From: Amanda Scholes on behalf of Planning.Responses
Sent: 08 June 2020 11:53
To: Planning Scanning
Subject: FW: 2020-05-15-19163-PARCELS A2 & B6, Littlehampton - Drainage Drawings

Paul Cann
Principal Drainage Engineer
Engineering Services

Comments;

Type B Manhole

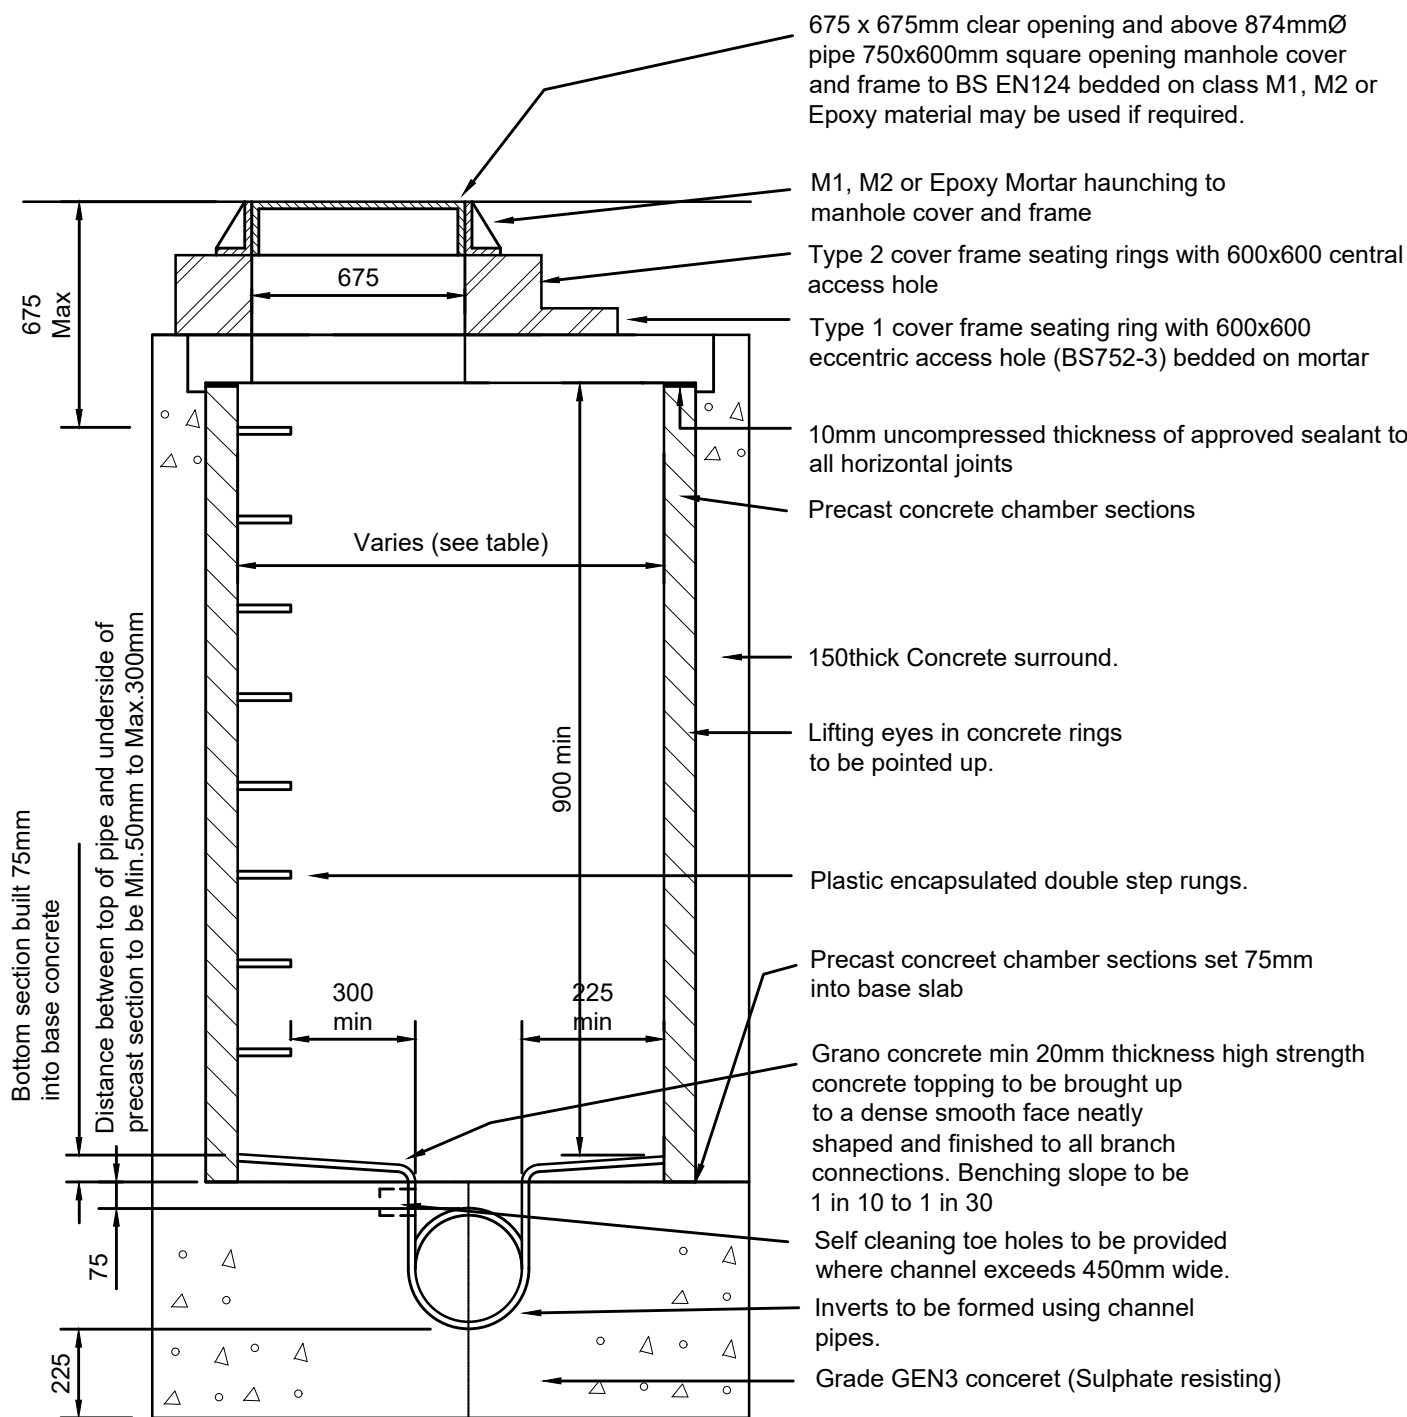
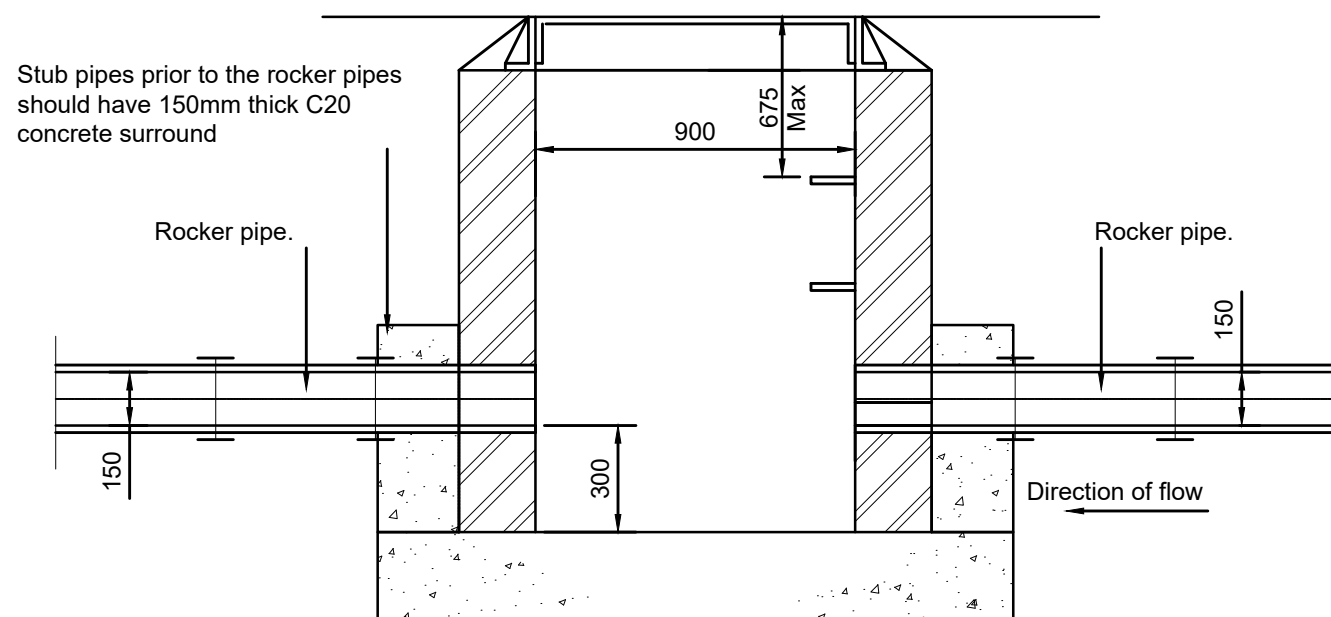
1. CP1 and CP2 (catchpits) on the manhole schedule drawing need to refer to a catchpit detail, not a type B manhole. ok
2. Provide non adoptable manhole construction details. ok
3. Provide channel drain construction details/spec. ok
4. Hydrobrake chamber HB01 construction detail – connect incoming 150mm connection from permeable paving at soffit to soffit level with 300mm pipe inlet. ok
5. Hydrobrake chamber HB02 construction detail – plan view shows incoming 900mm pipe as opposed to 300mm and 1.8m dia rings as opposed to 1.5 dia. Incoming 150mm connections to connect soffit to soffit with 300mm pipe. The gully that is connecting against flow and above hydrobrake is not ideal but willing to accept it in this instance (Section A-A shows it in a different location to the plan view?) ok

Flow Control Chamber HB1

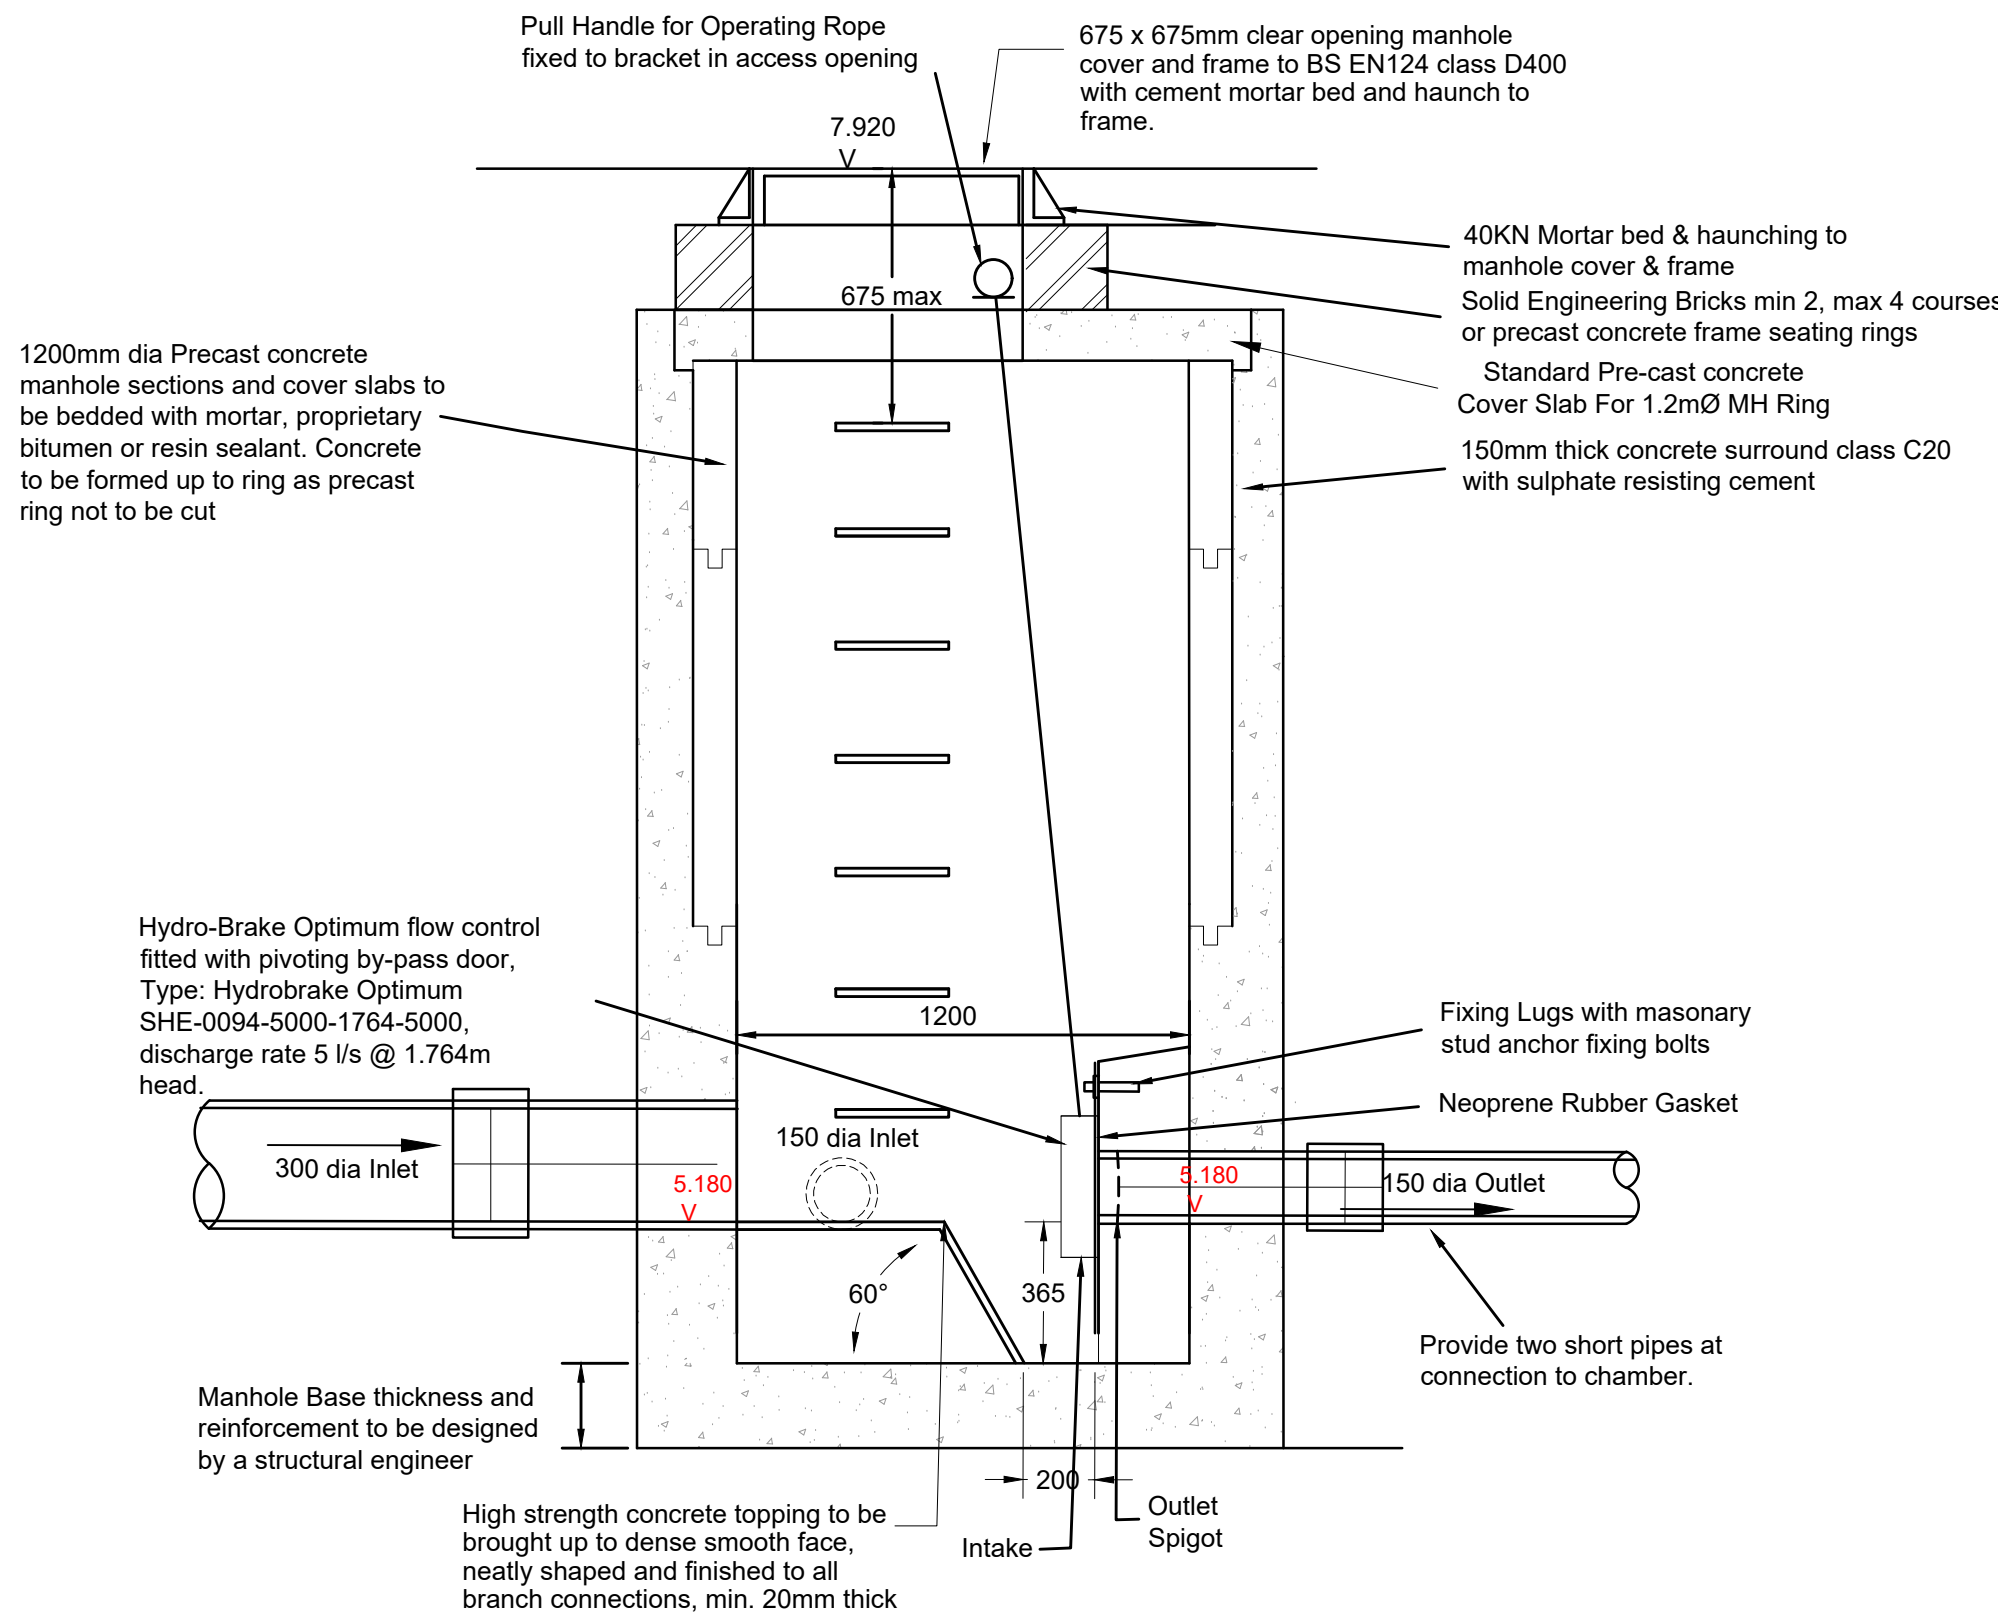
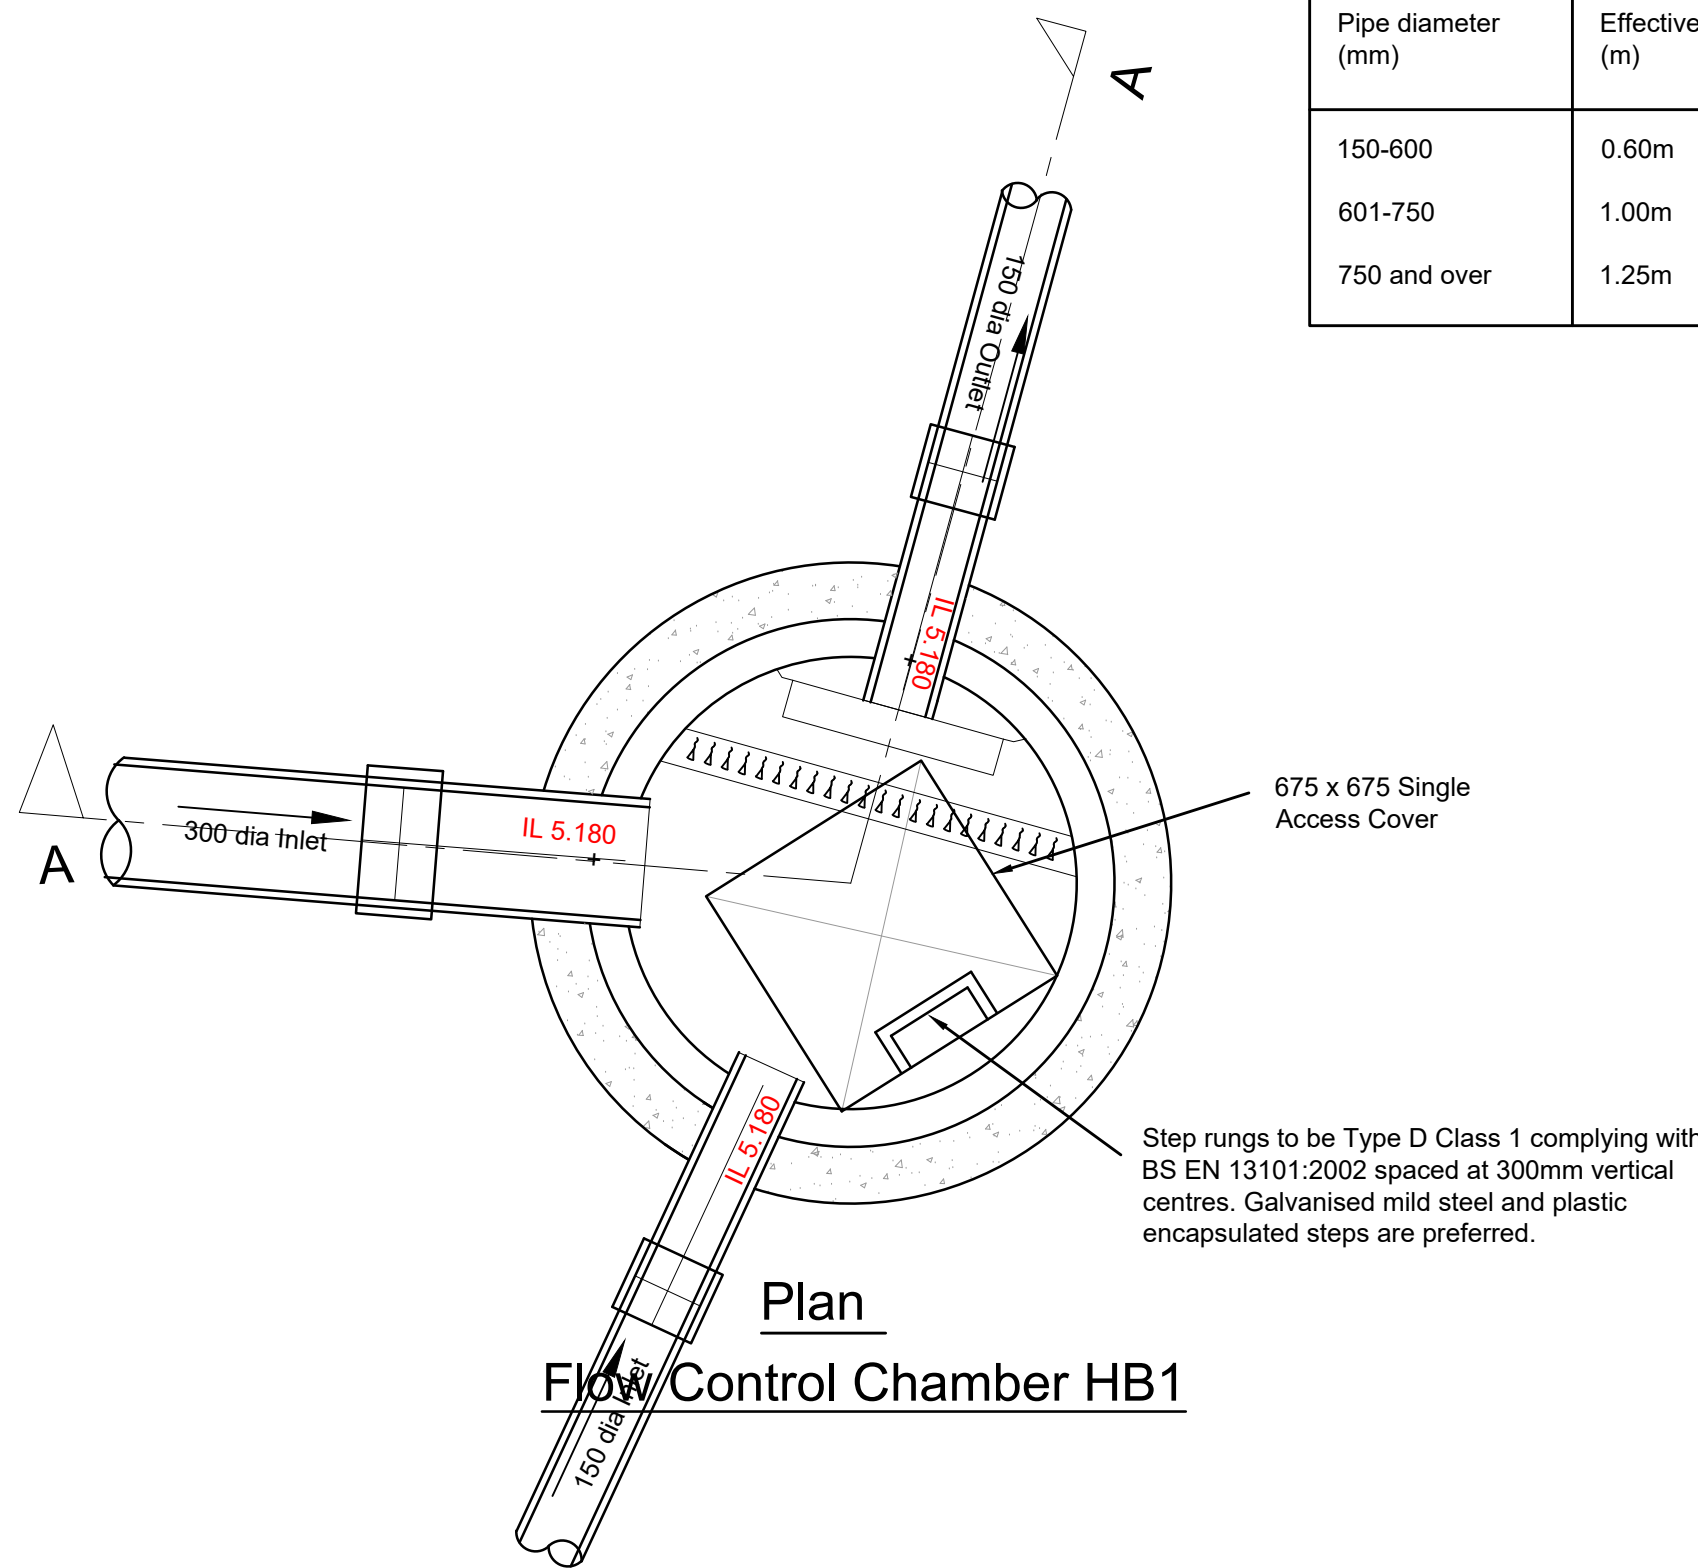
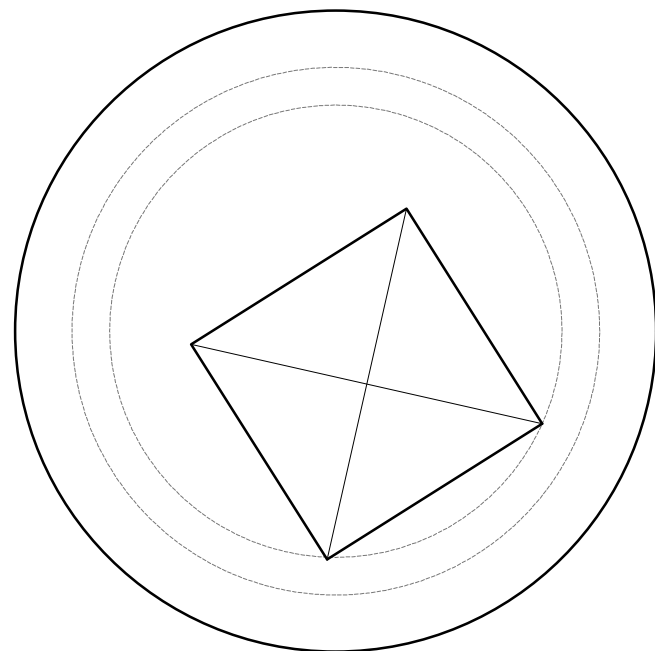
6. Both hydrobrake chambers – show base thickness/reinforcement details. *ok*
7. Existing manhole SW03A – just upstream of SWA2_01 – what is its purpose? Invert level is lower than the downstream manhole. Please clarify if it is required and adjust as necessary. *Removed - ok*
